Site	Russell Vale Colliery	DOC ID	RVE EC PLN 010
Туре	Plan	Date Published	19/11/2021
Doc Title	Extraction Plan

Russell Vale Underground Expansion (MP09_0013) Extraction Plan

EPA Comments - Russell Vale Underground Expansion Project - Stage 1 Extraction Plan

HERITAGE COUNCIL COMMENTS ON DRAFT STAGE 1 EXTRACTION PLAN FOR RUSSELL VALE COLLIERY (MP09_0013-PA-12)

FIGURE 4
 Proposed Stage 2A Surface Infrastructure
 Components without Coal Processing Plant

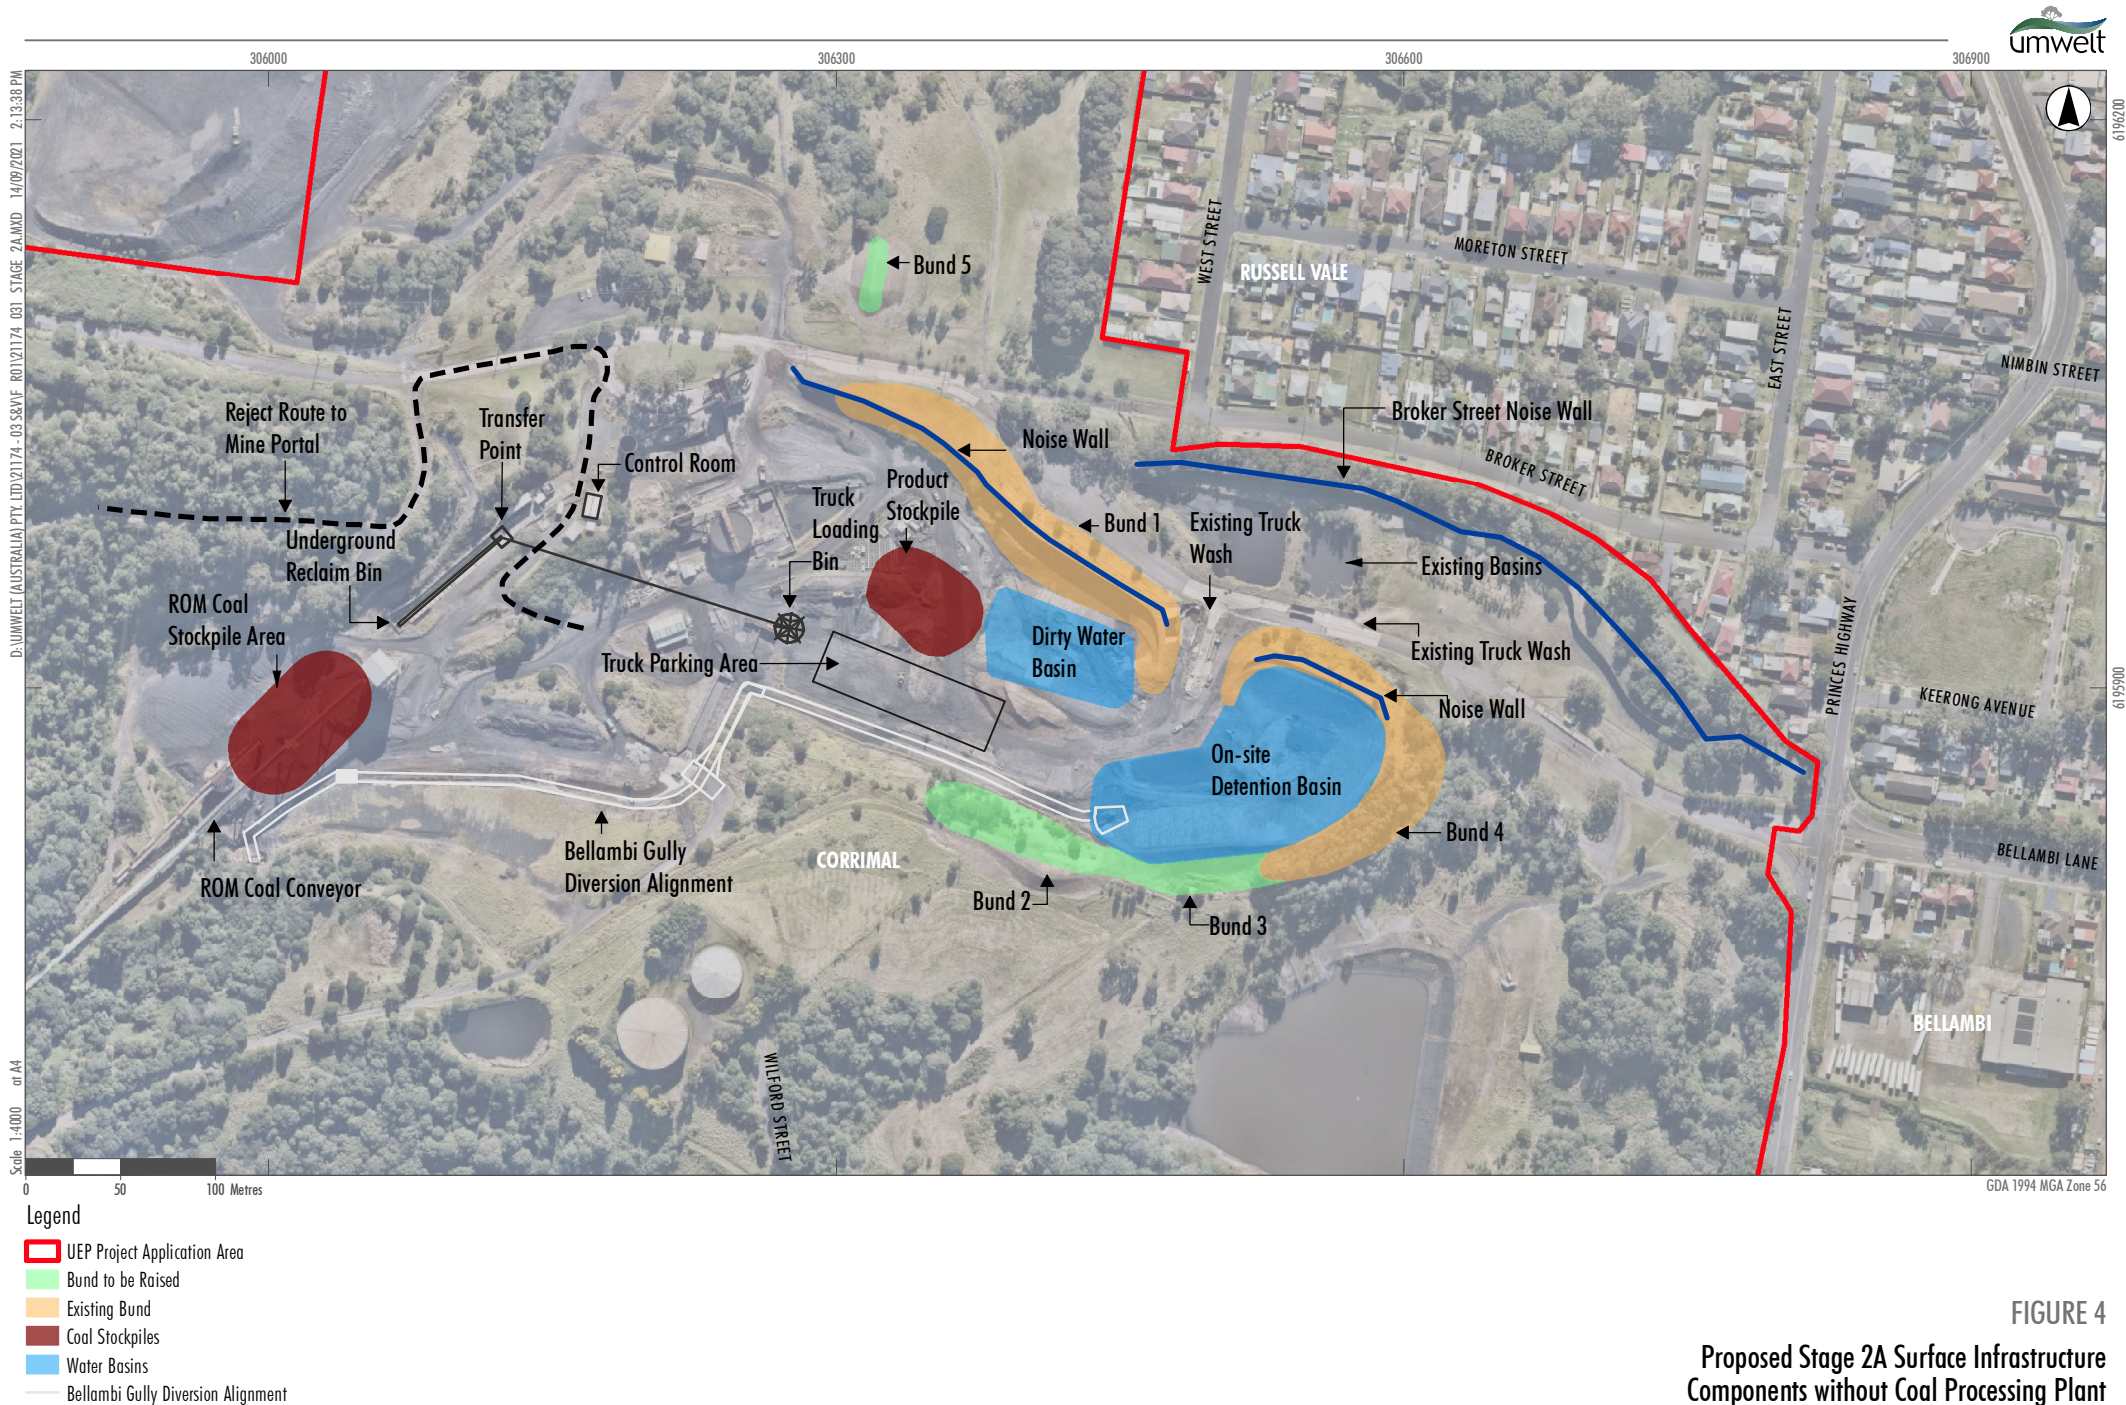
The plan states that Stage 1 includes an "evaluation of the feasibility of a coal processing plant (CPP) to be installed as part of the new Stage 2 surface infrastructure".

The EPA understands that the Revised Preferred Project Report and evaluation of environmental impacts during the planning approval included a new coal processing plant. If the plant is built as part of the project, the EPA recommends that expert confirmation be provided by Wollongong Coal that noise and dust impacts will be no more than those predicted in the environmental assessment and approved in the Consent.
